# MCDONALD'S AT FONTAINE AND MARKSHEFFEL GRADING AND EROSION CONTROL VILLAGE AT LORSON RANCH FILING NO.1 LOT 2

GRADING AND EROSION CONTROL PLAN	
SHEET NUMBER	SHEET TITLE
C2.1	COVER
C2.2	NOTES
C2.3	INITIAL EC
C2.4	FINAL EC
C2.5	CUT FILL PLAN
C2.6	EROSION CONTROL DETAILS
C2.7	EROSION CONTROL DETAILS
C2.8	EROSION CONTROL DETAILS
C2.9	EROSION CONTROL DETAILS
C2.10	EROSION CONTROL DETAILS

TITLE	CONSTRUCTION DRAWINGS	PREPARED FOR:	McDonald's USA, LLC
DESCRIPTION	INITIAL EC	PREPARED BY:	Kimley»Horn
SITE ID	51028	DATE	
		REV	
		DESCRIPTION	
		BY

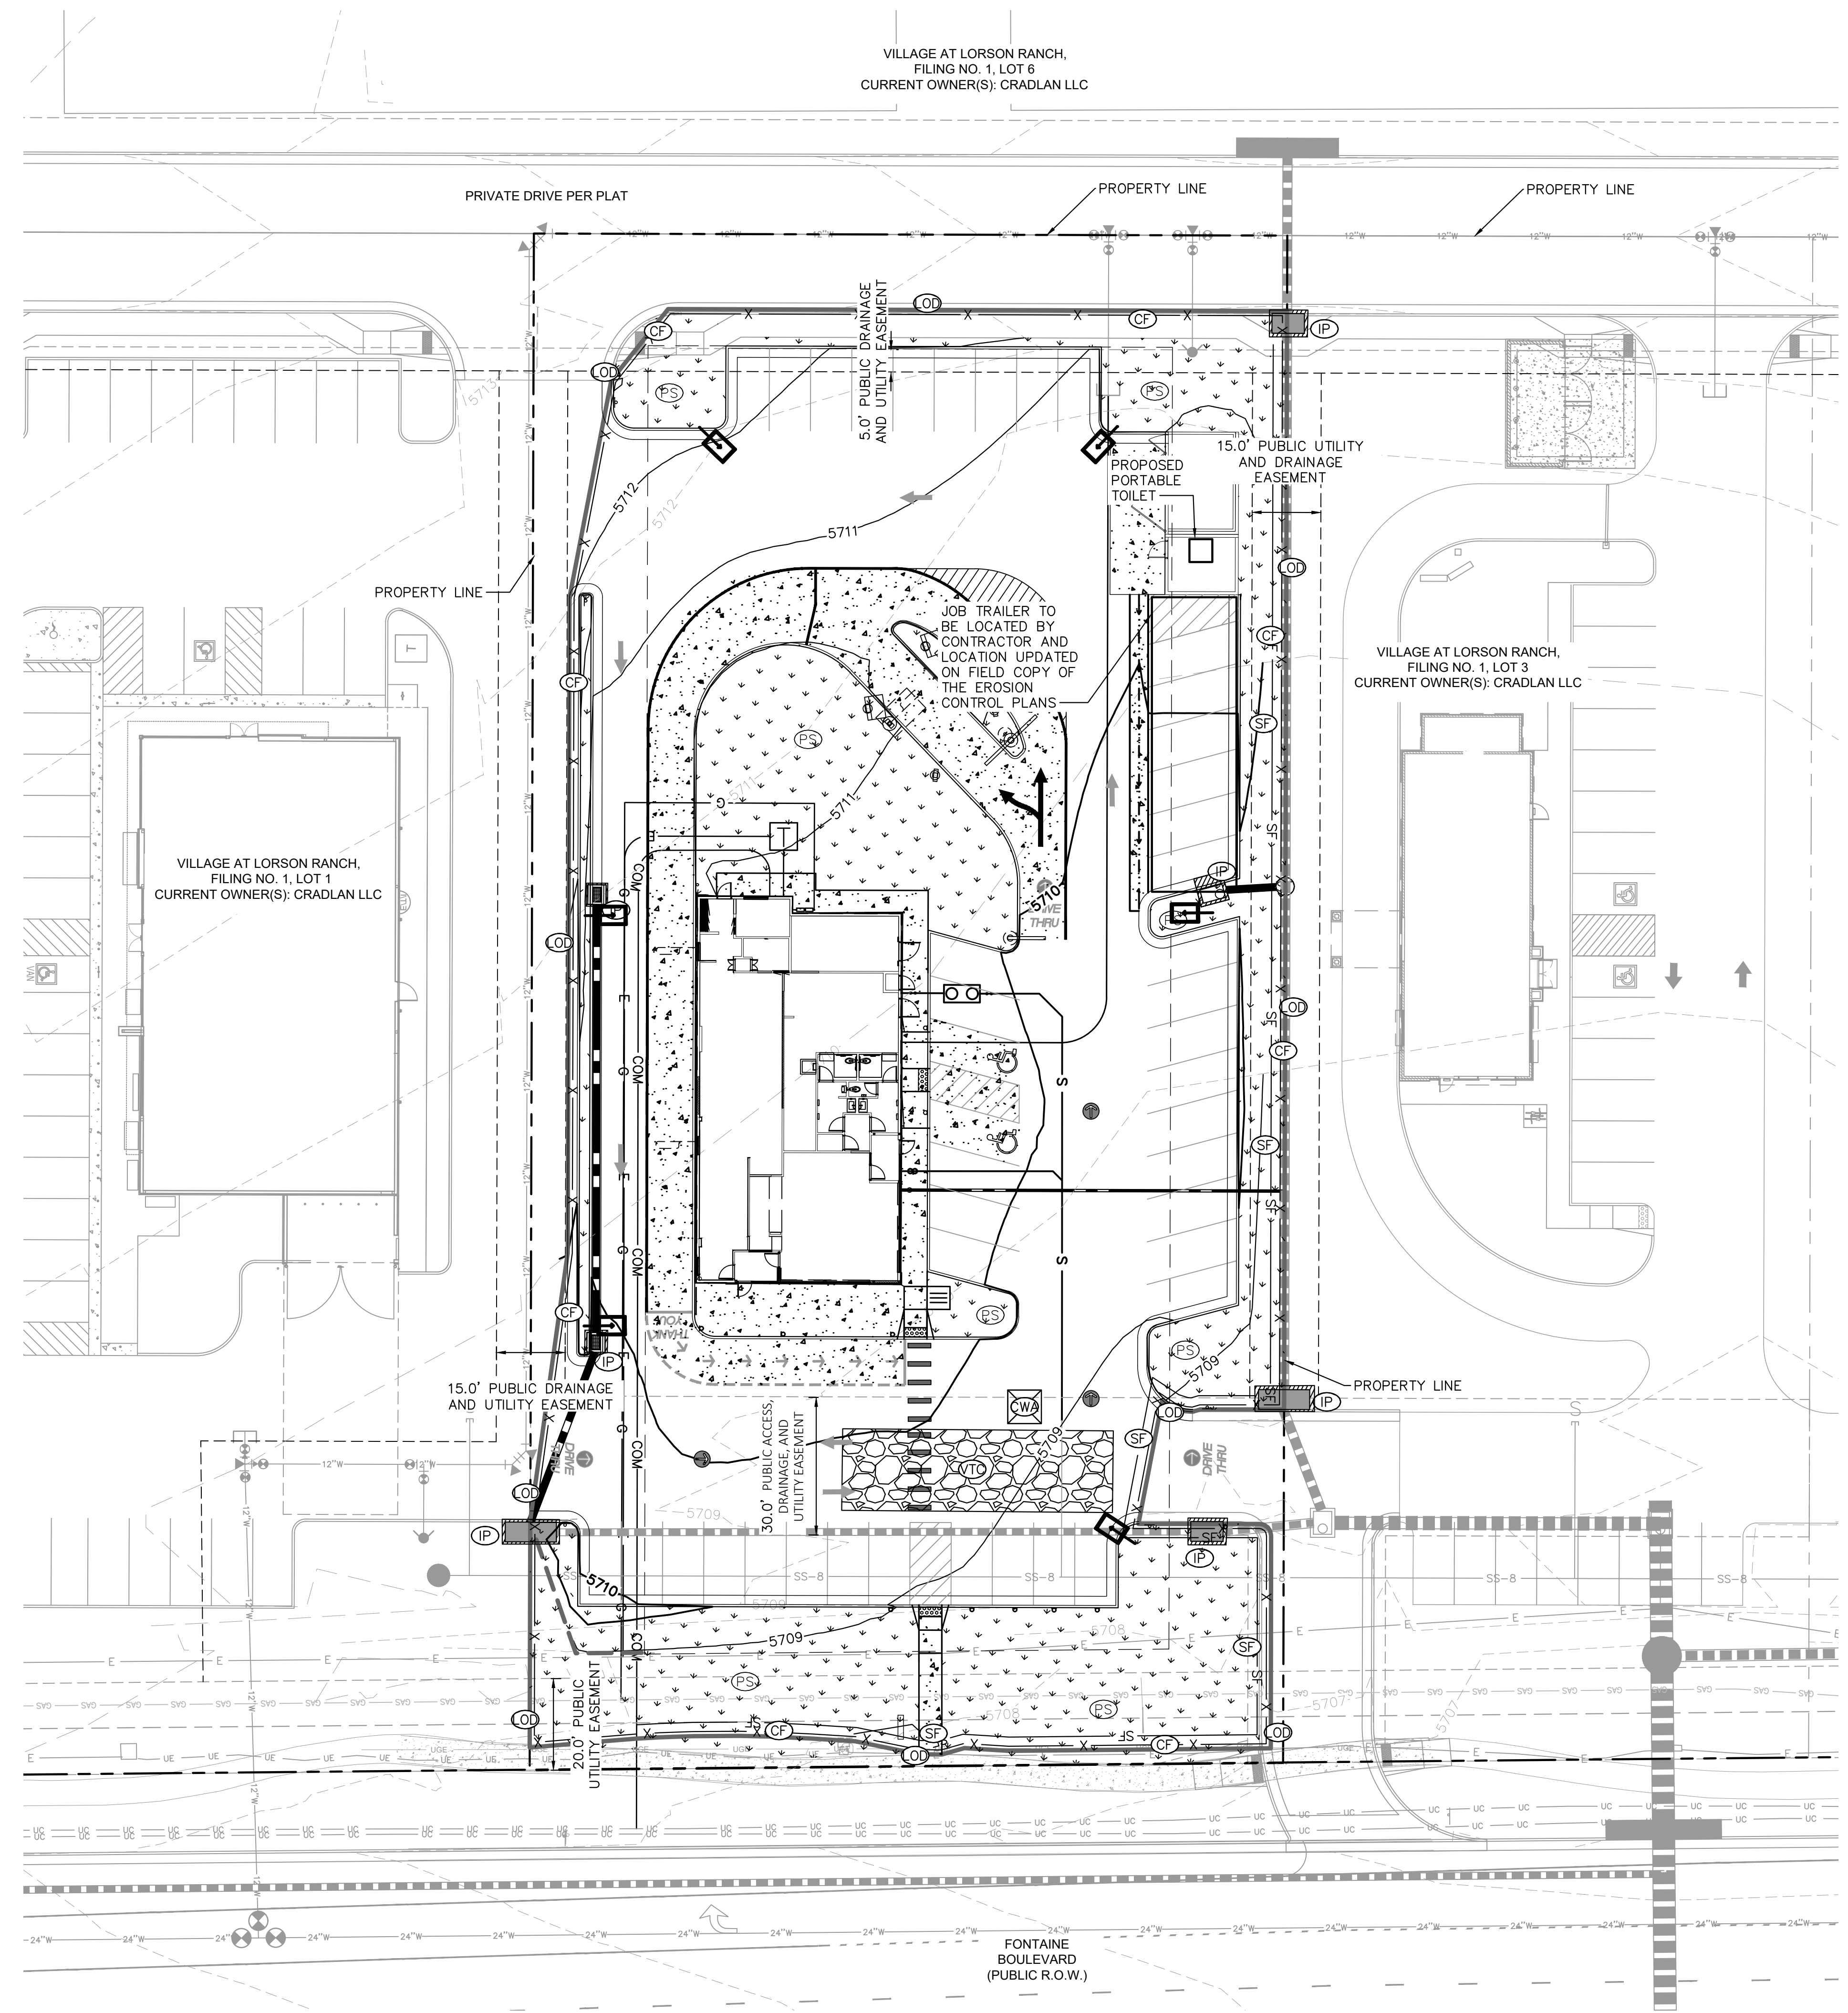
Please move the VTC to the north side of the site, where construction traffic is expected to exit the site. See screenshot above, showing yellow highlights at the location for your pad onto "Center Village Heights" a private road.

LOD linetype doesnt match from plans to Legend.
